Heritage Council

RE: Response to modification to amend the approved landscape masterplan and signage strategy for the Australian Technology Park, Eveleigh (SSD 7317 MOD 12)

Tim Smith OAM
Director Heritage Operations
Heritage Division
Office of Environment & Heritage
As Delegate of the NSW Heritage Council
7 August 2018

WELLNESS PRECINCT

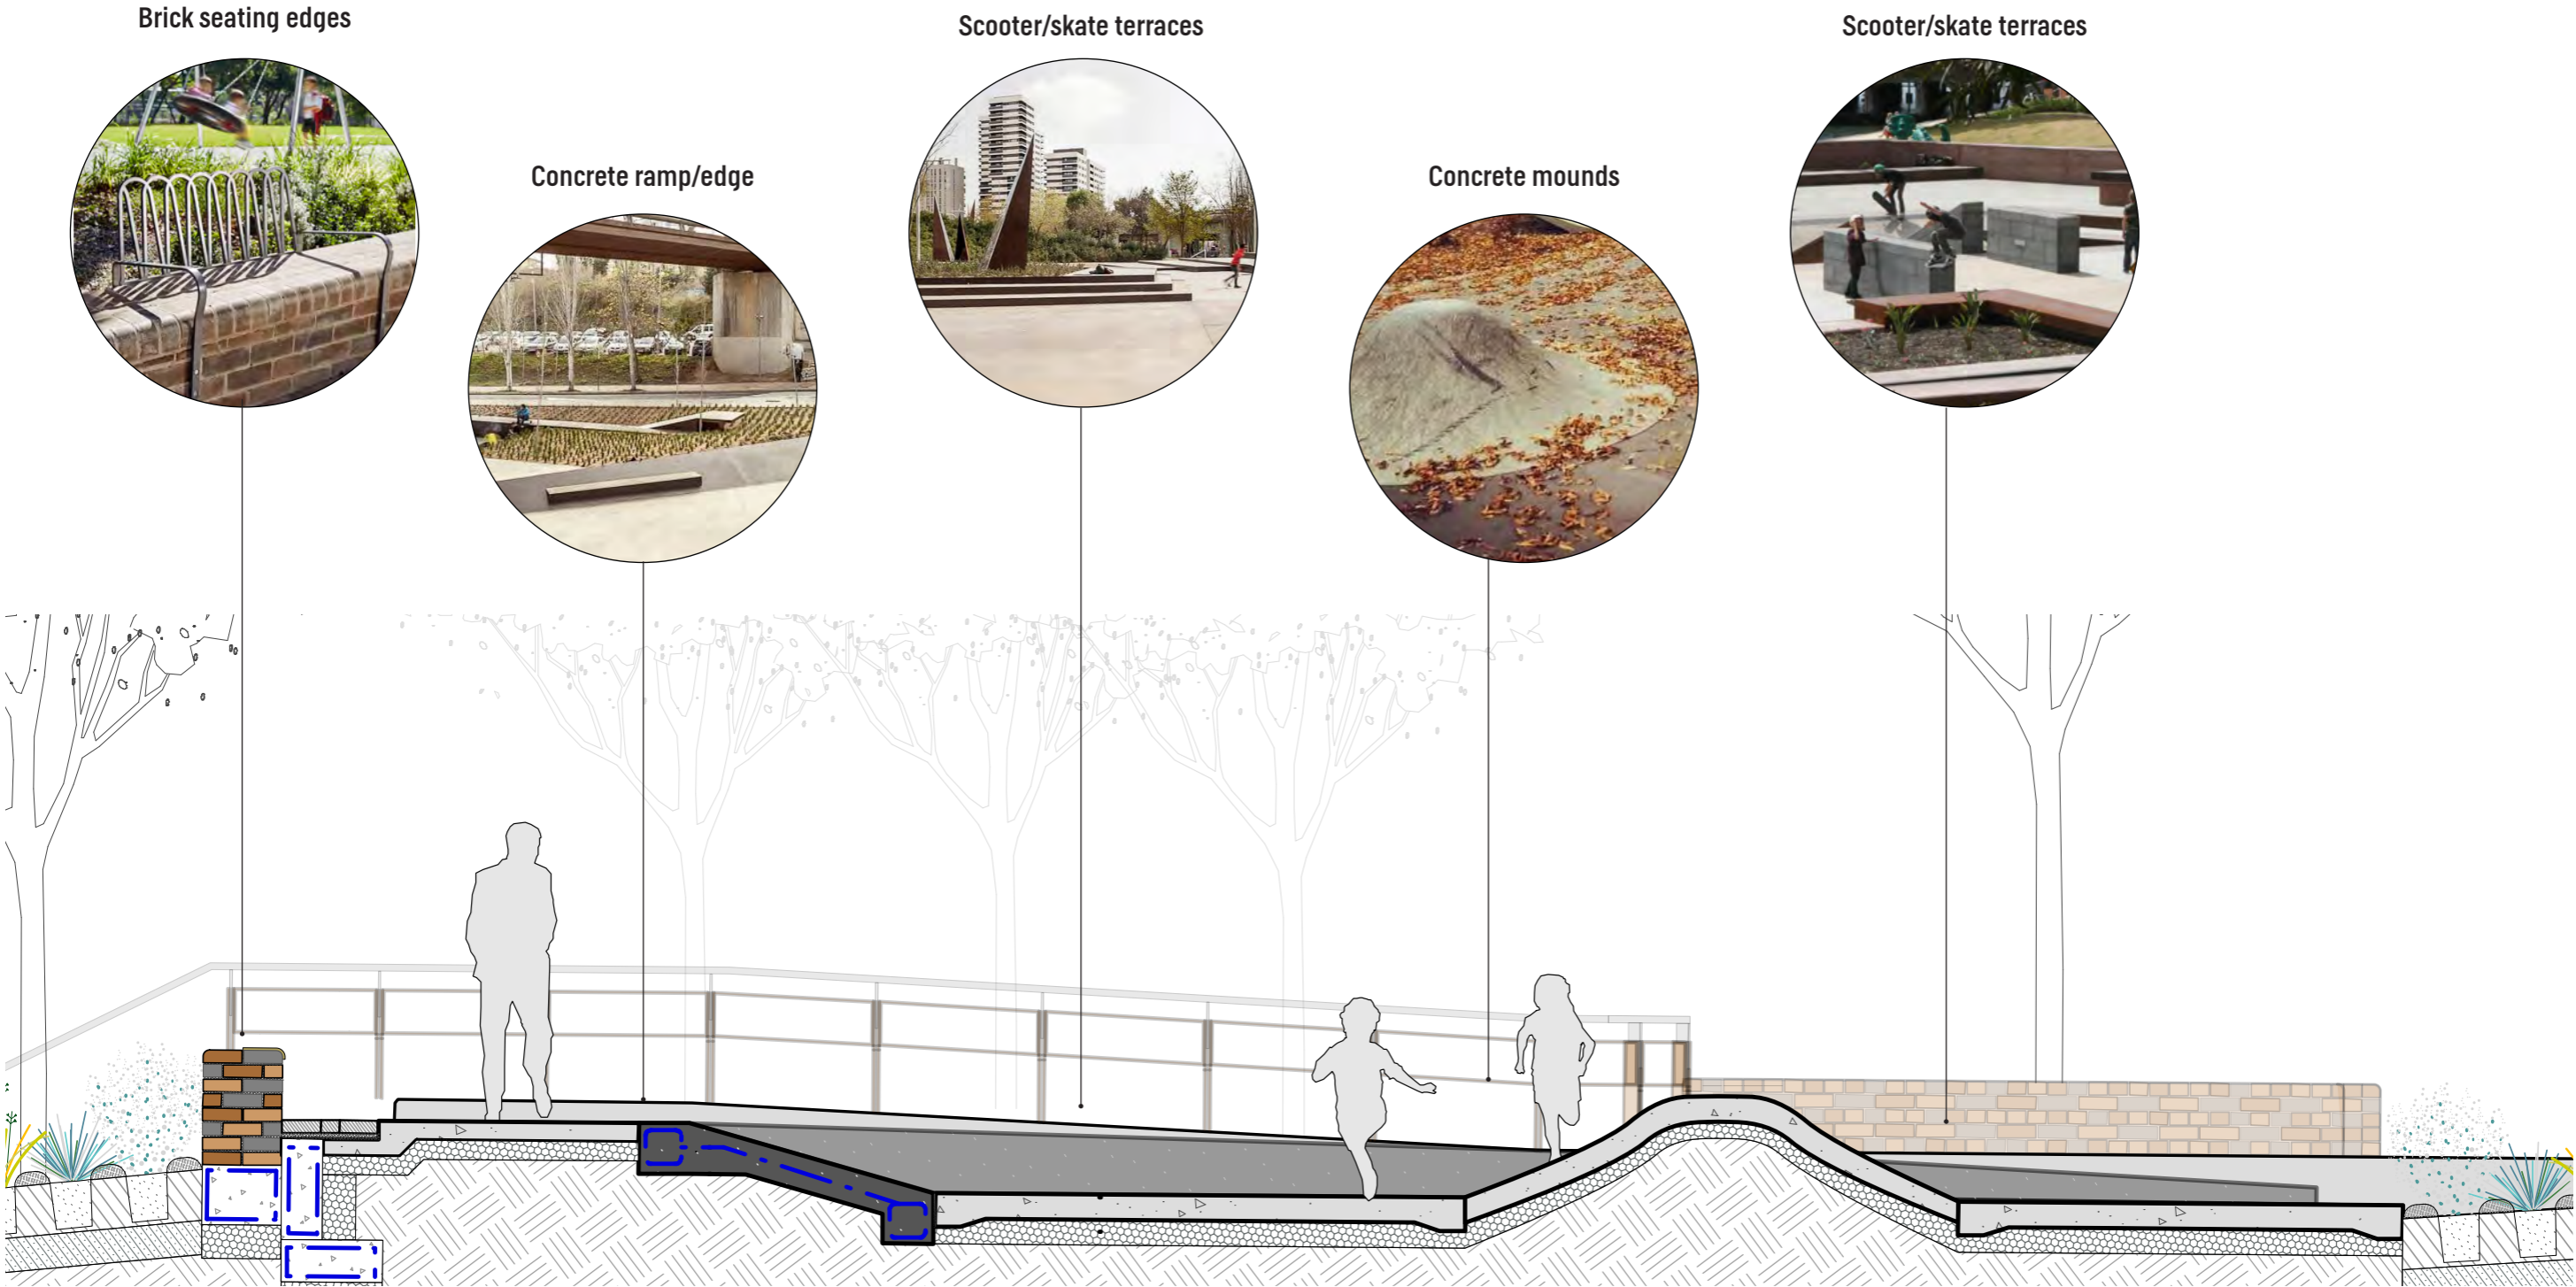
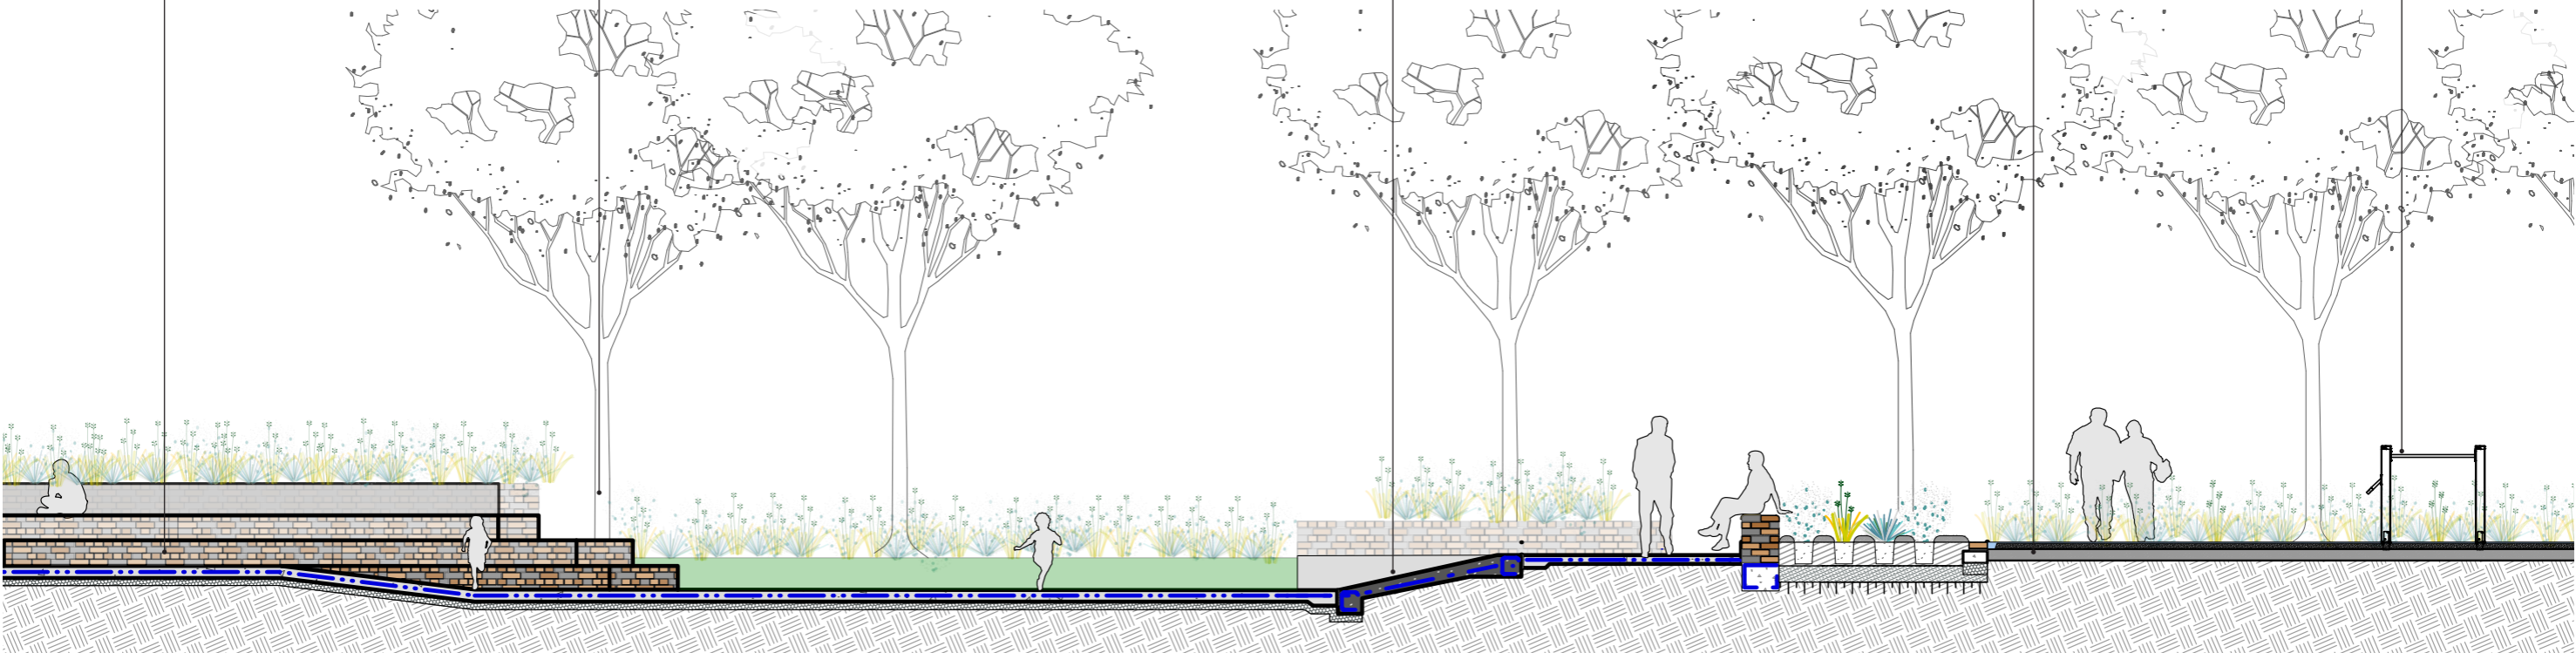
It is understood that a Wellness Precinct, which includes a junior scooter park, is proposed adjacent to the existing sports courts along the south-east boundary of ATP. Whilst the proposed location, on the edge of the site and a clear distance from the Locomotive Workshops, is considered supportable, it is unclear what level of excavation will take place, and what the potential impact to any archaeological relics will be. It is therefore recommended that the following condition be provided:

The applicant must ensure that if unexpected archaeological deposits or relics not identified and considered in the supporting documents for this approval are discovered,

work must cease in the affected area(s) and the Heritage Council of NSW must be notified. Additional assessment and approval may be required prior to works continuing in the affected area(s) based on the nature of the discovery.

In addition, it is noted that interpretation elements are being developed as part of the Stage 2 Heritage Interpretation Plan. **It is recommended that this is undertaken in consultation with the Heritage Council.**

GEN GEN Signage Family Overview - Interpretive

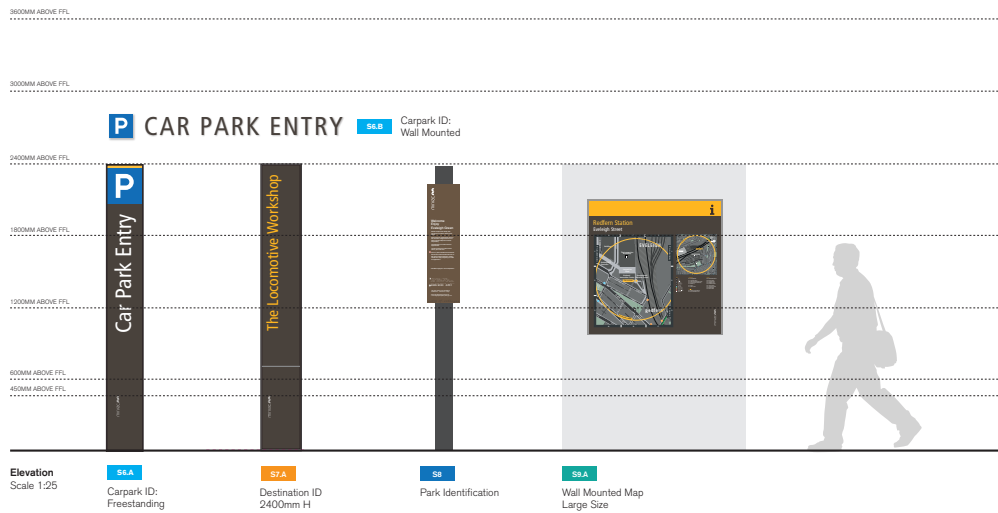
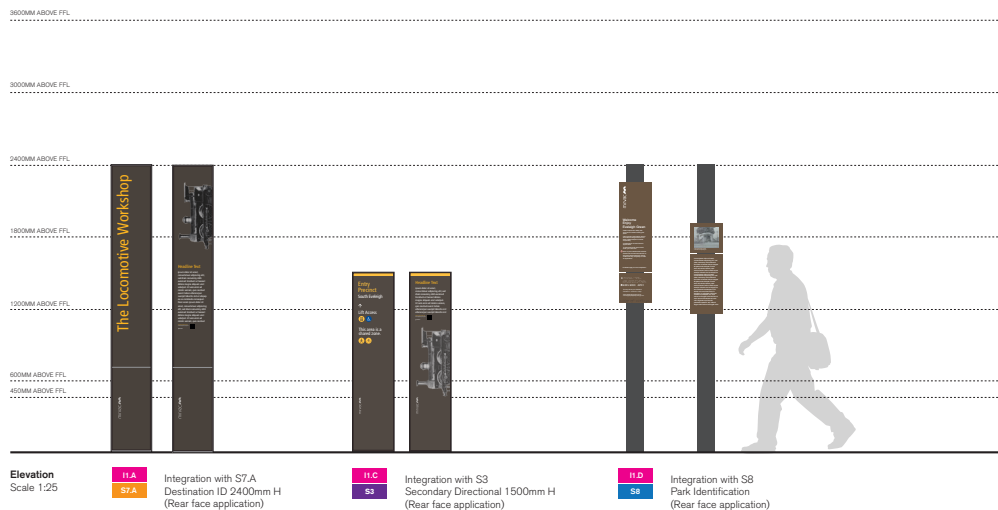
We are generally supportive of the provided Signage Strategy. It is noted that the proposed signage performs both identification and wayfinding signage functions. In addition, many of the signs incorporate interpretation as part of the design. **It is recommended that the final interpretative design of the signage be provided to the Heritage Council for comment.**

It is understood the proposed signage utilises the City of Sydney wayfinding system in an attempt to integrate the ATP precinct into the wider City of Sydney (CoS) area. Whilst this is considered reasonable, it should also be noted that ATP is part of the State Heritage Register (SHR) listed Eveleigh Railway Workshops site. **It is therefore recommended that a defining design element be incorporated into the signage which situates the ATP site within the broader SHR curtilage, and which speaks to the industrial heritage of the site. This should be separate to the interpretive elements of the signs.**

# EVELEIGH GREEN

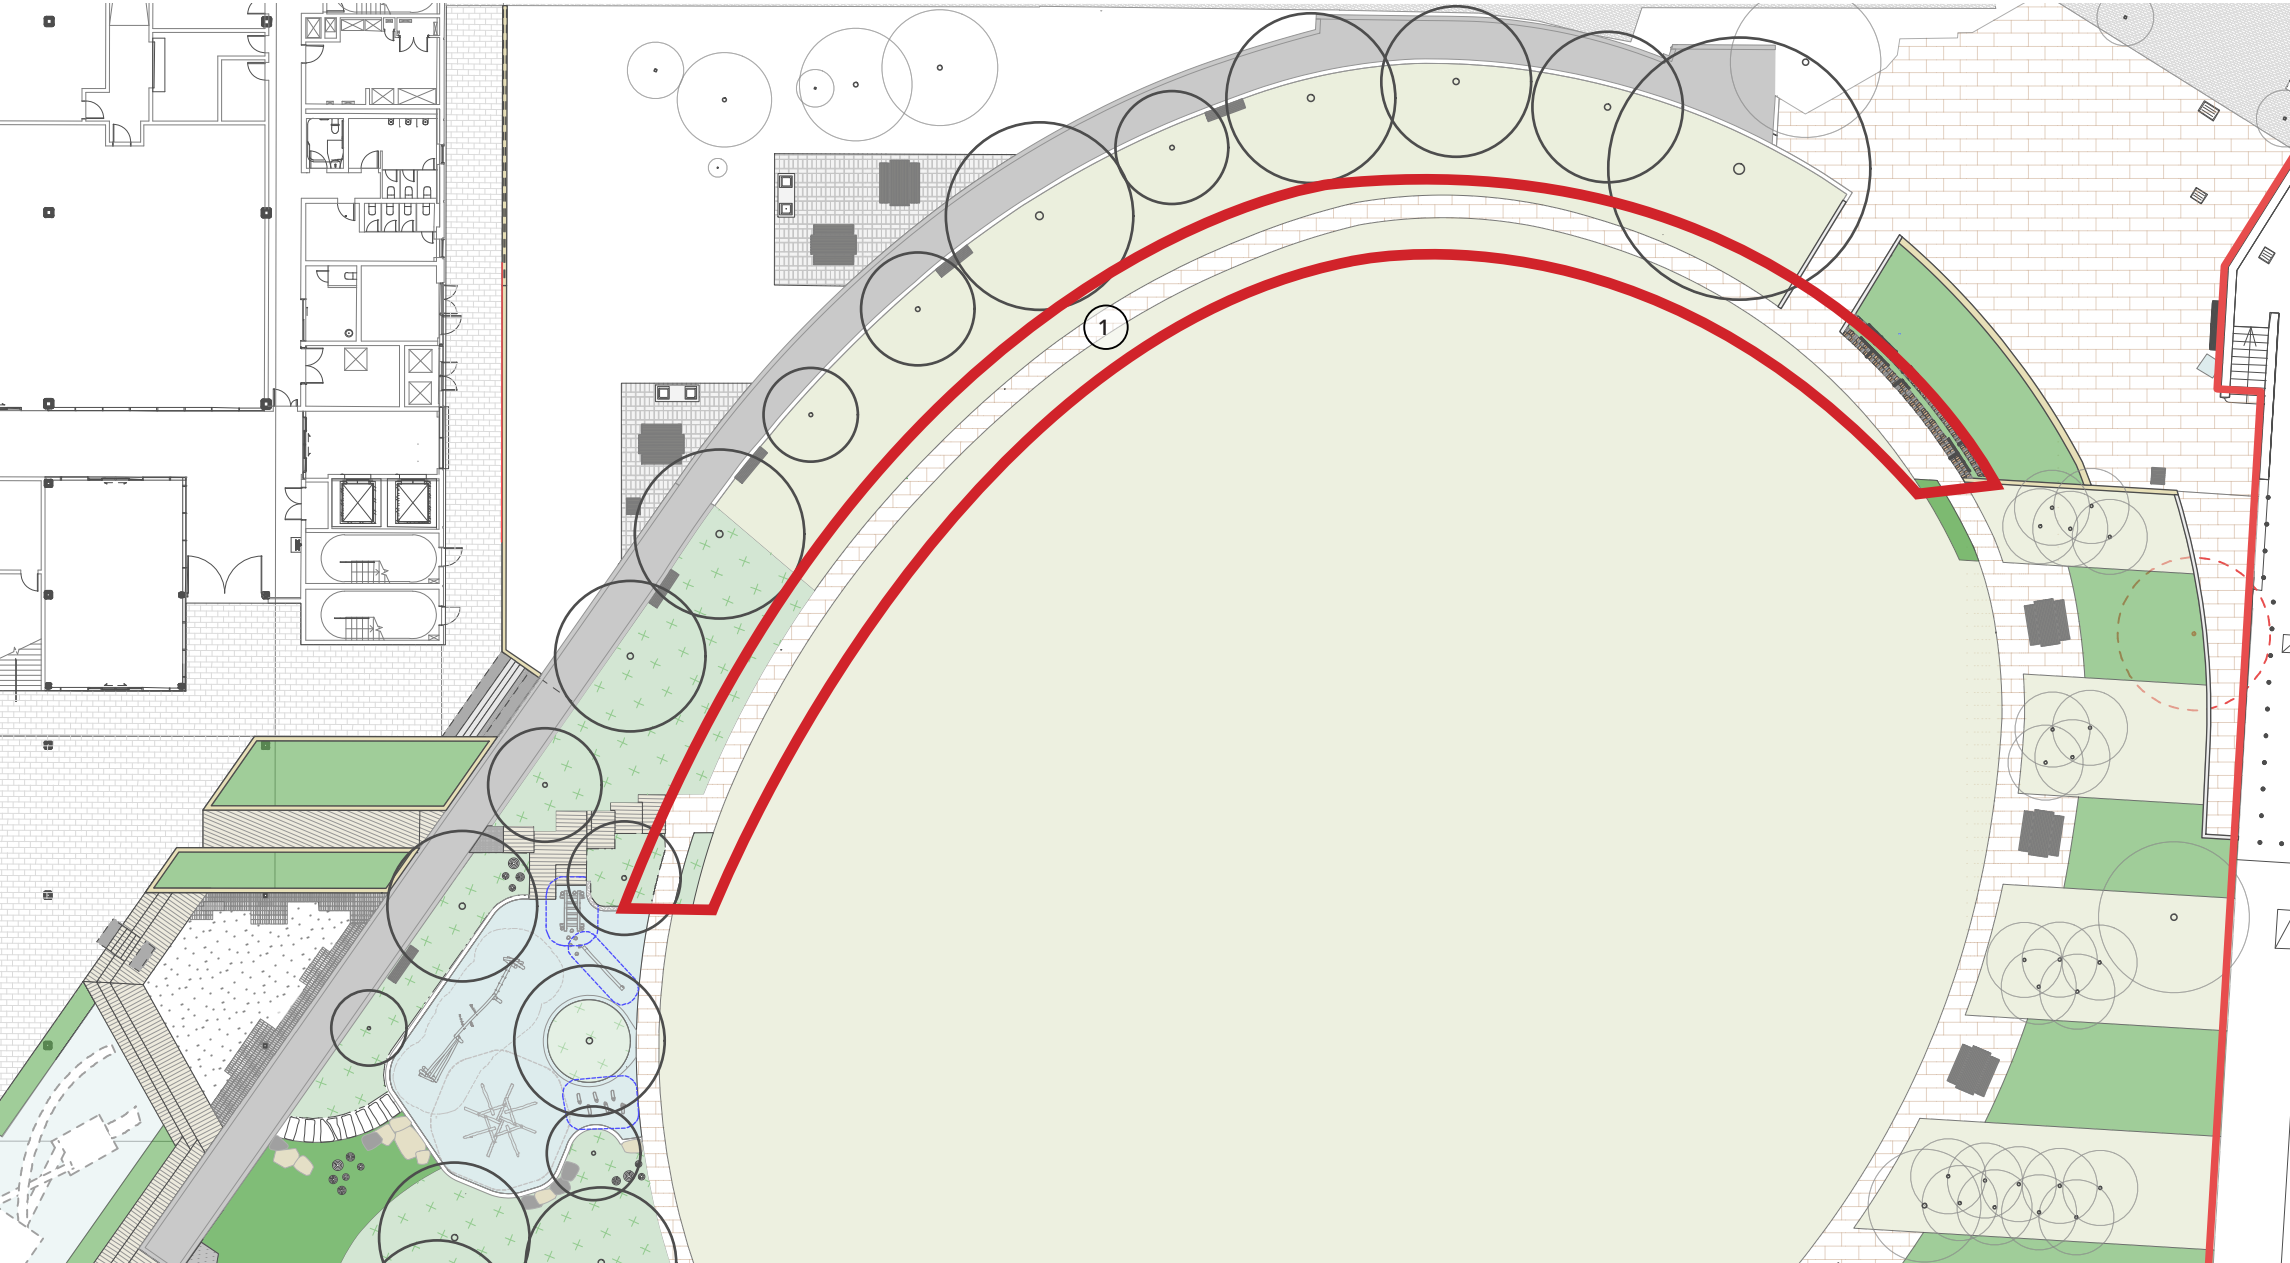
The proposed change to the brick pathway around the oval is supported as it is required to avoid impacting on tree roots of the existing trees.

# LANDSCAPE FEATURE LIGHTING

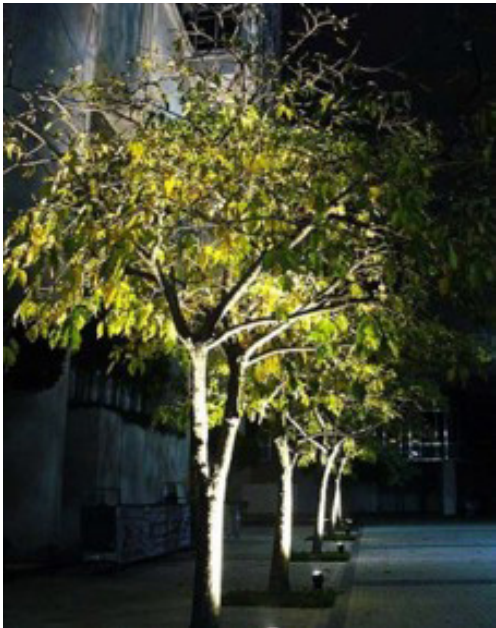
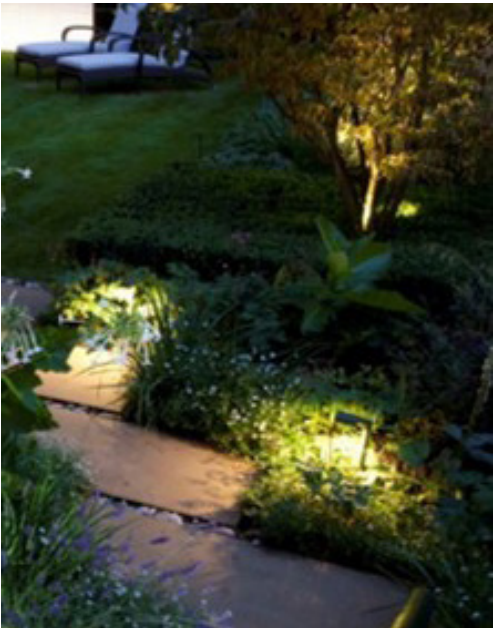
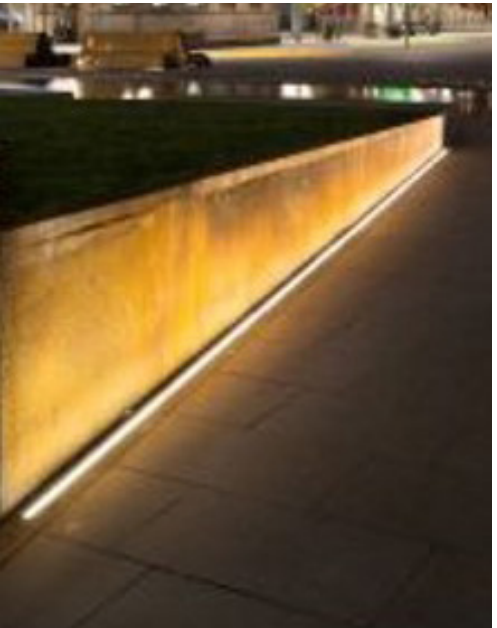
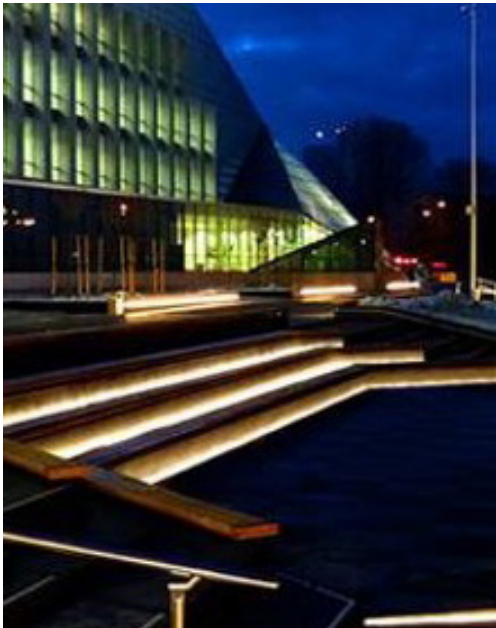
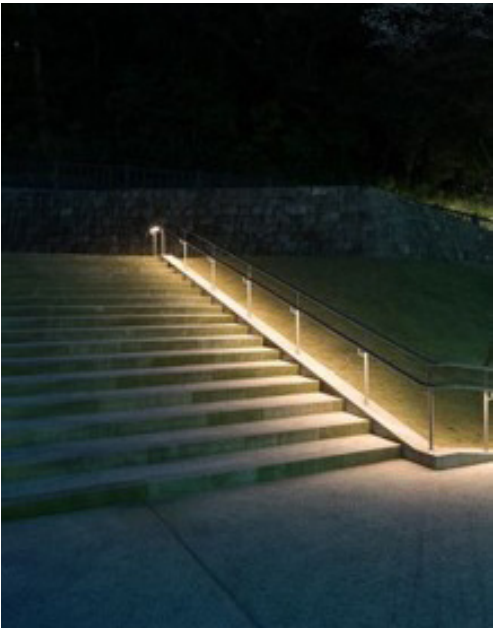
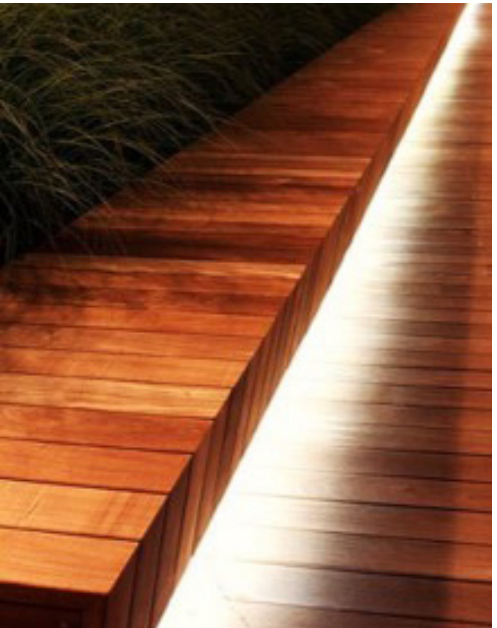
It is understood the detailed design of the landscape feature lighting is currently being developed. Concept designs provided indicate discrete integration of lighting within handrails, landscape walls and seating, and are generally supported. **It is recommended that feature lighting also be investigated for moveable heritage items. This should be developed as part of the Stage 2 Interpretation Plan and provided to the Heritage Council for comment.**
